**From:**  
**Sent:** 02 December 2025 14:37  
**To:** Louise Bearcroft; DC Admin; Hazel Irving  
**Cc:** Trees Planning; Yorkshire and North East TSOs; england@woodlandtrust.org.uk  
**Subject:** Fwd: Planning Applications 2025/61/92713/E- Consultation Response - Ref 46/96

Re: Planning Applications 2025/61/92713/E

I have reviewed the AMS which has been submitted Ref. 220218b, dated 10.11.2025 that you have based your decision on, this is not showing the trees in our garden correctly classified and they are not in the correct location. The last page of the AMS Ref 220218b prepared by James Royston Tree Protection Plan to BS5837:2012 at Moor Lane, Gomersal is showing our trees referenced as G17. These trees are located in our

Appendix 5: Tree protection plans

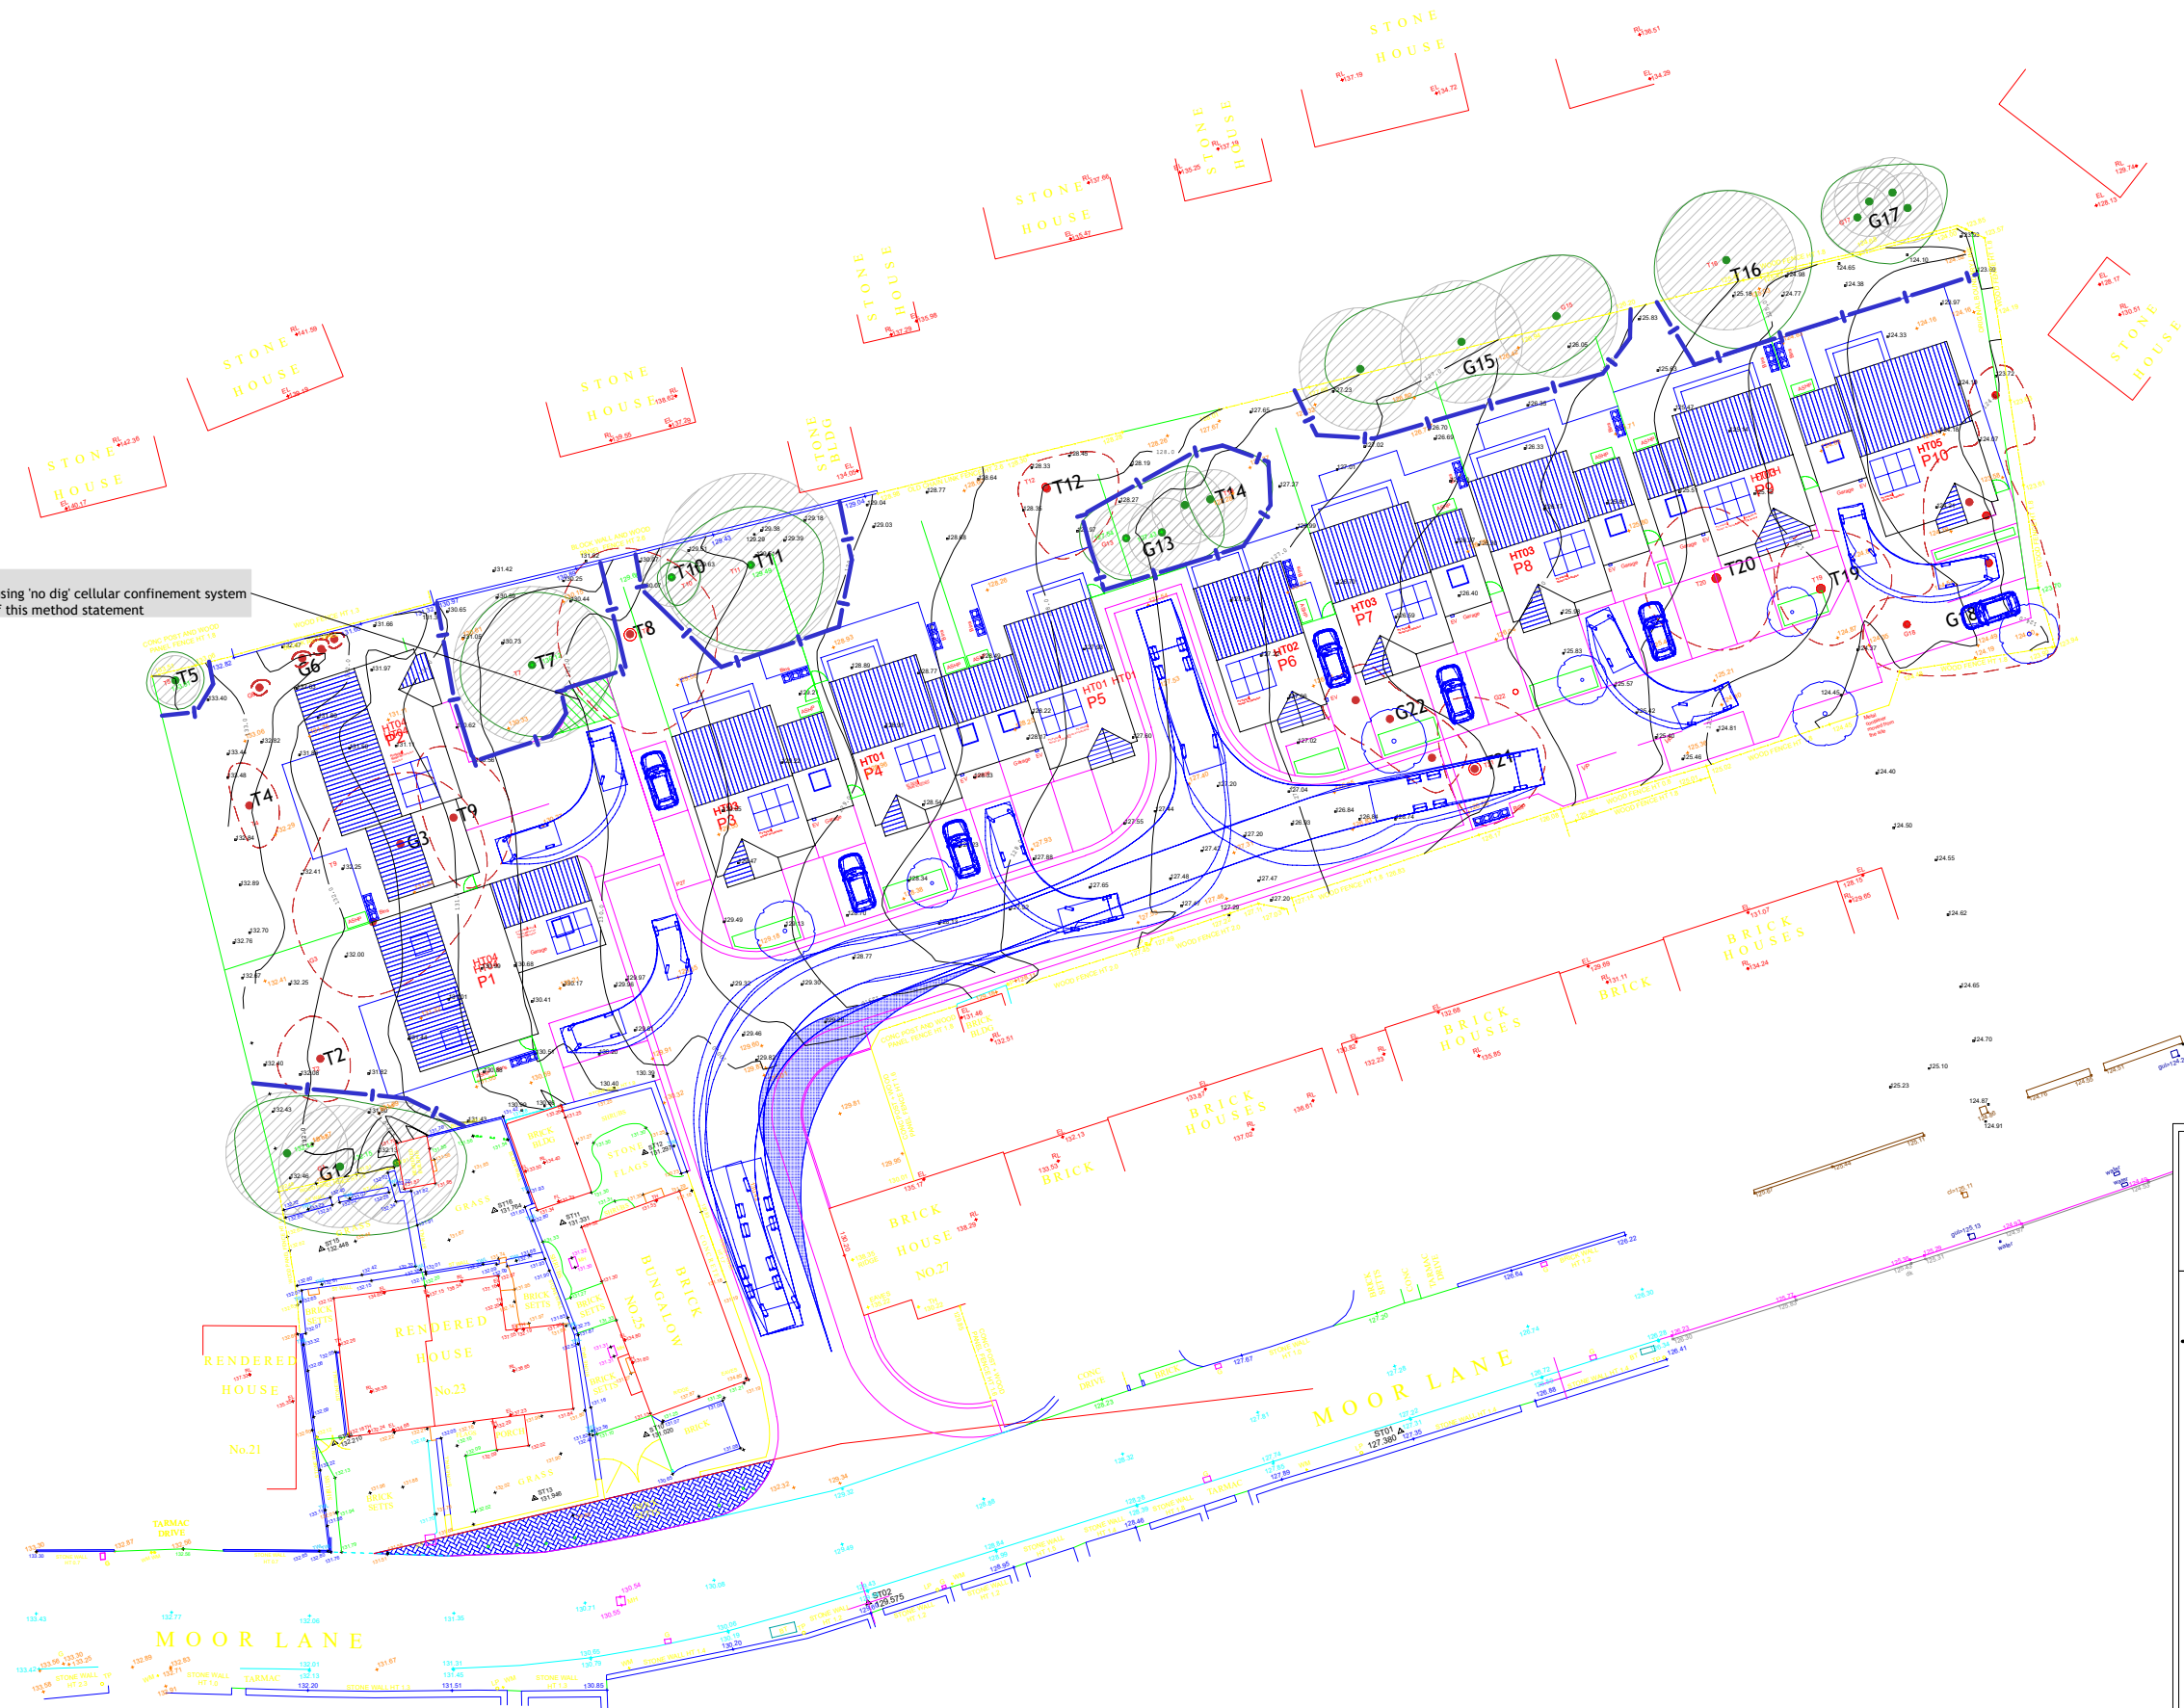
back garden at 21 Summerdale, Gomersal, Cleckheaton, BD19 4AH. On this plan G17 is showing 4 trees, there are in fact 8 trees. These 8 trees have a TPO on them. The TPO number is 05 of 2025.

The location of the trees appears to be incorrect and the size they are depicted as is far too small. Some of these 8 trees are as big and tall as the tree marked T16 on these plans.

I have measured the correct distances of the 8 trees and here are those details:

Distance of nearest tree from 21 Summerdale garage 11.5 metres

Distance from the western boundary 2.7 metres

Distances from the wooden boundary fence in 21 Summerdale's garden, the 2 nearest trees to this boundary are 36 centimetres and 28 centimetres

I am concerned this development does not appear to be protecting the root ball of these TPO trees as adequately as it should, when compared to the other trees on the plan, a few metres away further west.

The lower branches on these trees are at least 7 metres over the boundary into the proposed plot. I am frightened that future workers will just come along with a chain saw and cut them back to the boundary, without getting TPO permission. This would put the trees out of balance and possibly kill them. Damage done now may not be visible for years after the developer has left the site. Any resultant damage from a falling tree etc. on a new house or garden could be charged to me. I find this grossly unfair as I have done everything I can to protect these trees. Can the developer be advised that these trees have a TPO on them and planning permission must be sort before any work can be undertaken?

I have now, because of this anomaly, looked at other plans on both applications (2025/44/92737 and 2025/61/92713) for this site and **all** the plans seems to be showing our trees incorrectly classified as G17 and the wrong number of trees shown. Do these plans need amending?
